CRAWLEY BOROUGH COUNCIL

RESPONSE TO GAL'S DRAFT ISSUES TRACKERS SENT ON 18 AUGUST 2023 OMISSION ISSUE TRACKER TABLES

15 SEPTEMBER 2023

Temporary NCR 21 Diversion

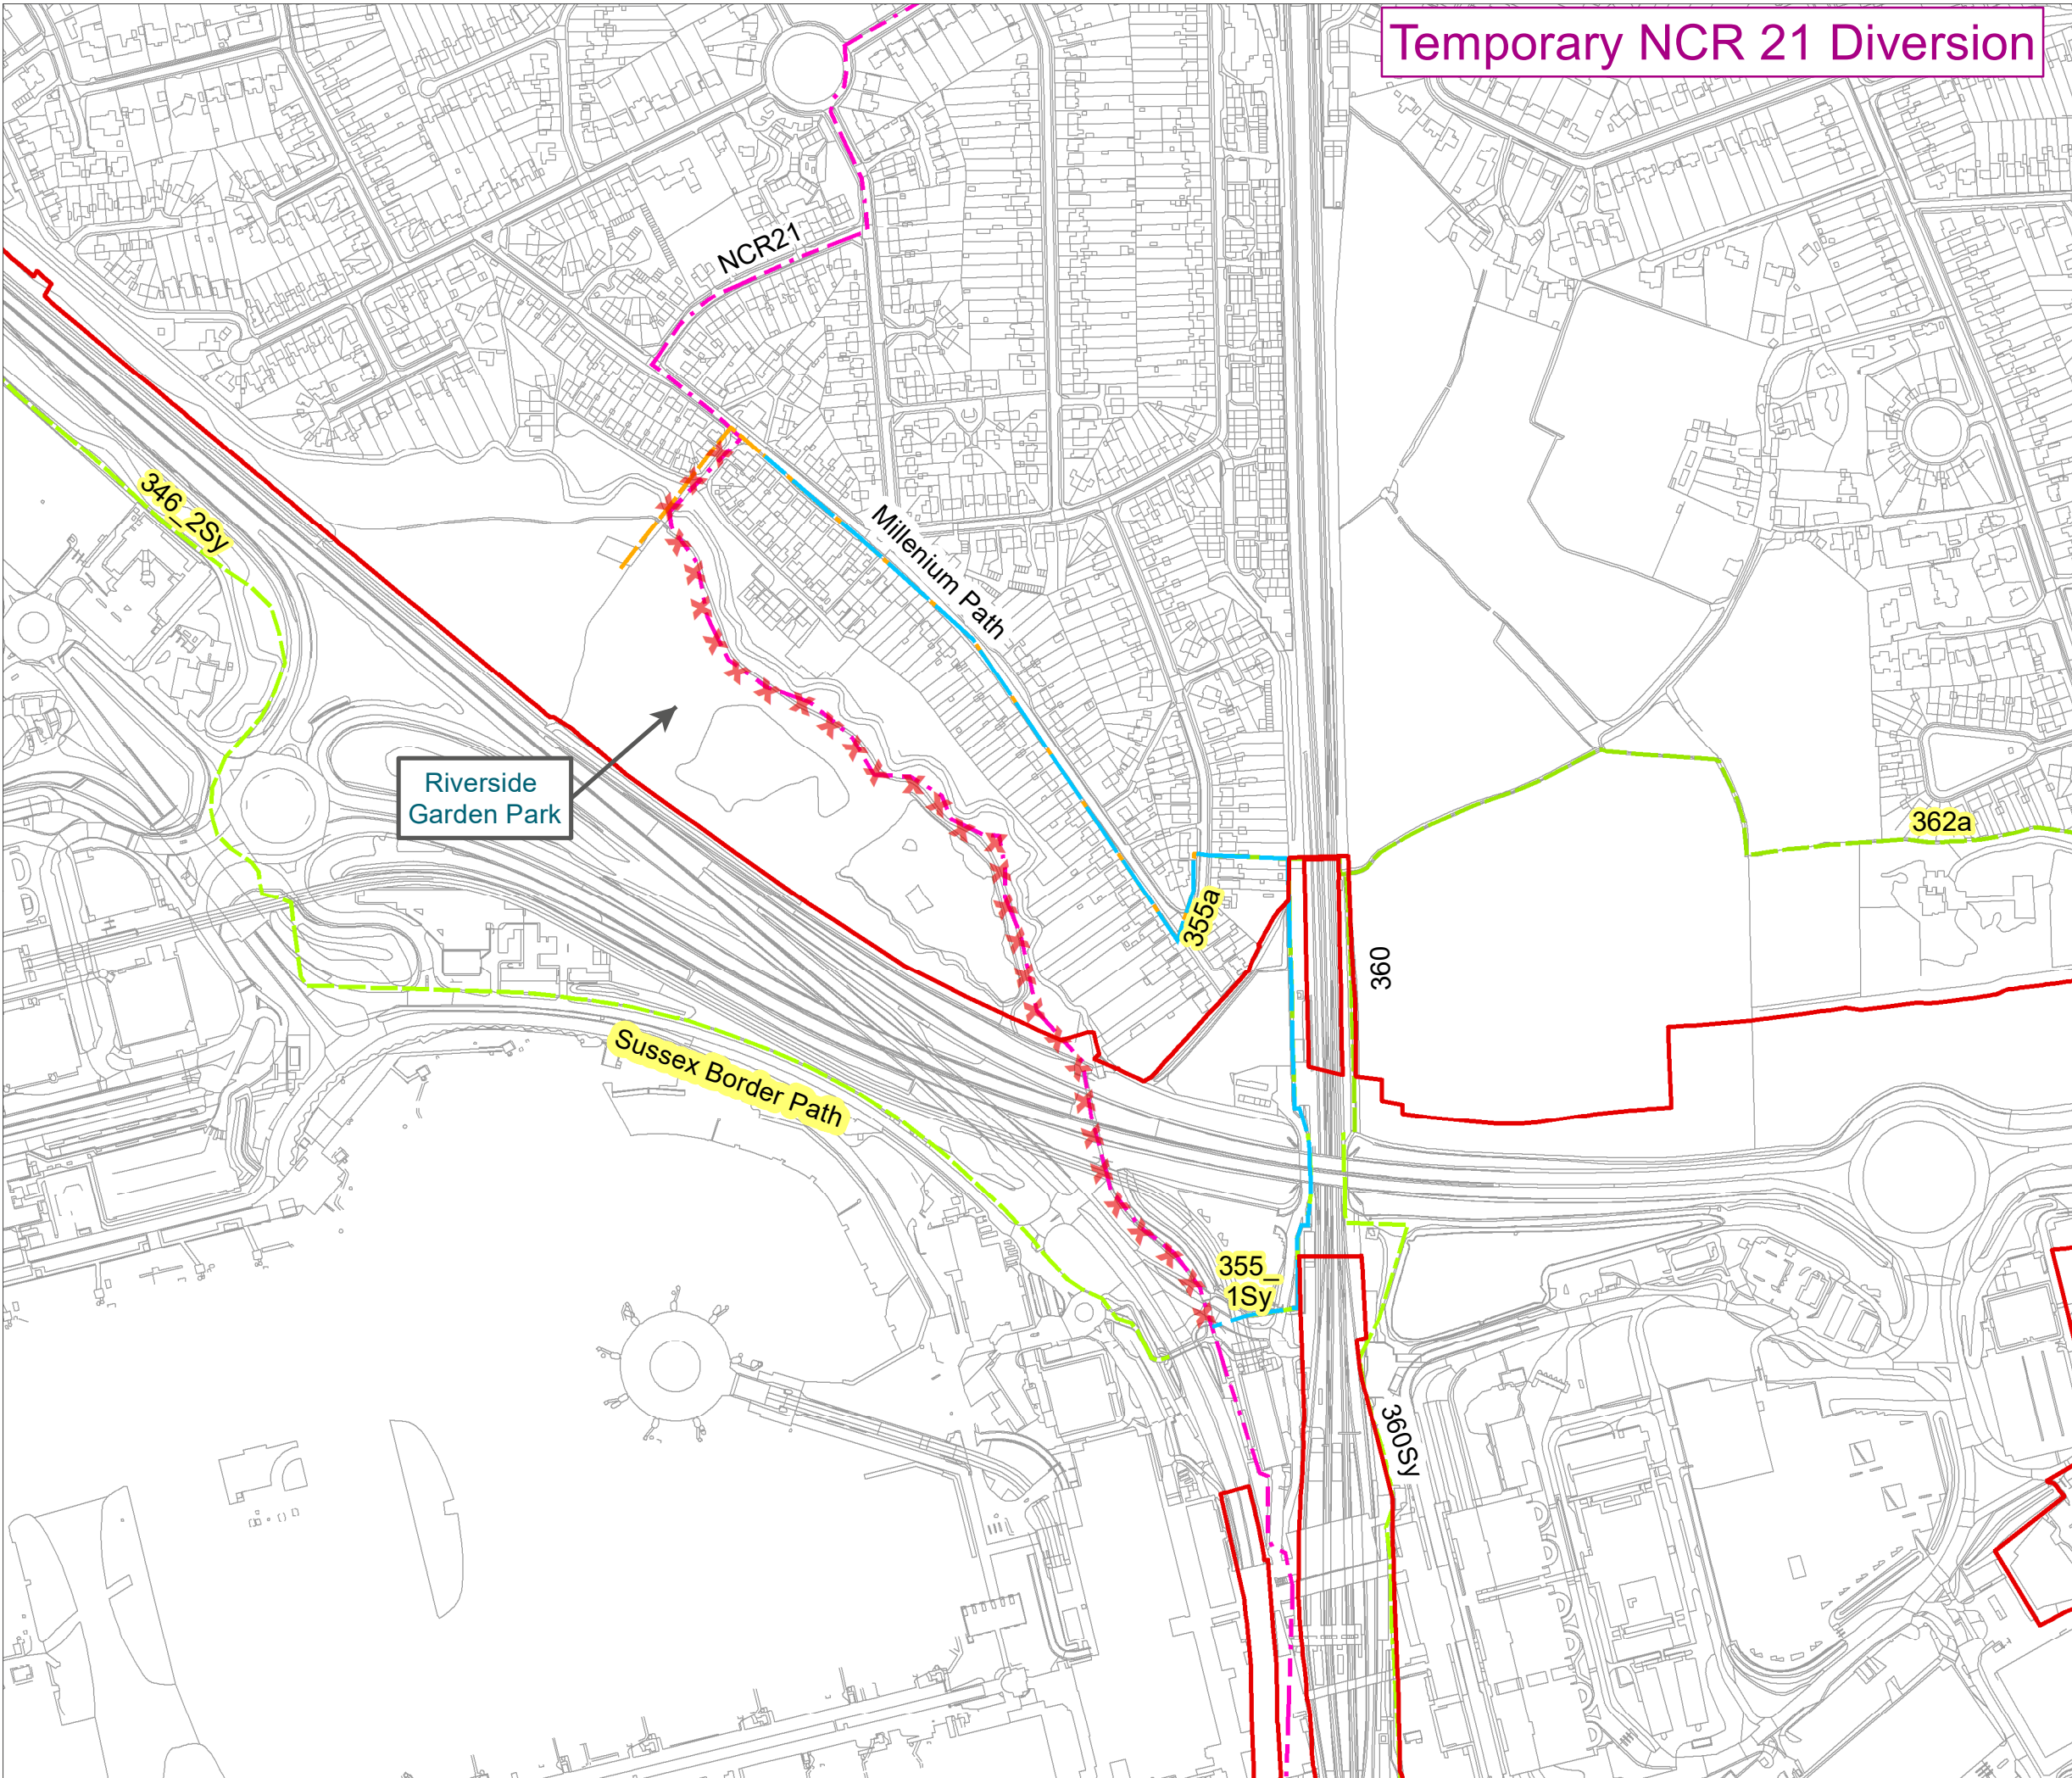
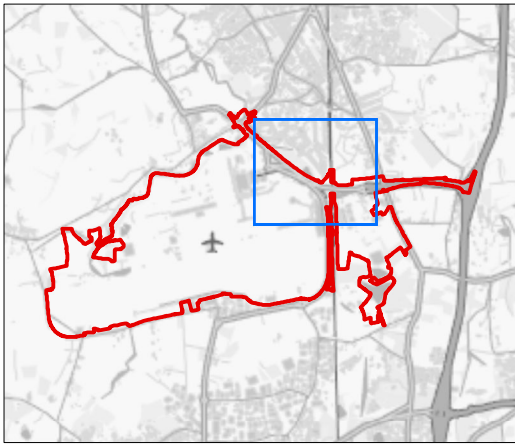
<p>Concern regarding indeterminate length of time of temporary diversions for walking and cycling routes during the construction period, including the Sussex Border path and NCN21. The plans to sever the key national cycle network route NCN21 require people on bikes to dismount and push for a significant distance which may not be possible for some people with mobility impairments. The proposed prohibition of cycling over a section of the NCN21 as indicated in the proposals will sever the existing continuous traffic free cycle facility. This section not only forms part of NCN 21 but also the transnational 'L'Avenue Verte' route between London and Paris.</p>	<p>Summer Consultation July 2022</p>
<p>The materials presented do not show any assessment of the quality of current active travel provision. The current provision is simply indicated as a given, but this is predominantly of poor quality, and does not meet the required standards. The quality of the existing NCN21 cycle route through the GAL campus is extremely poor, as is the condition of some of the public footpaths which are</p>	<p>Summer Consultation July 2022</p>
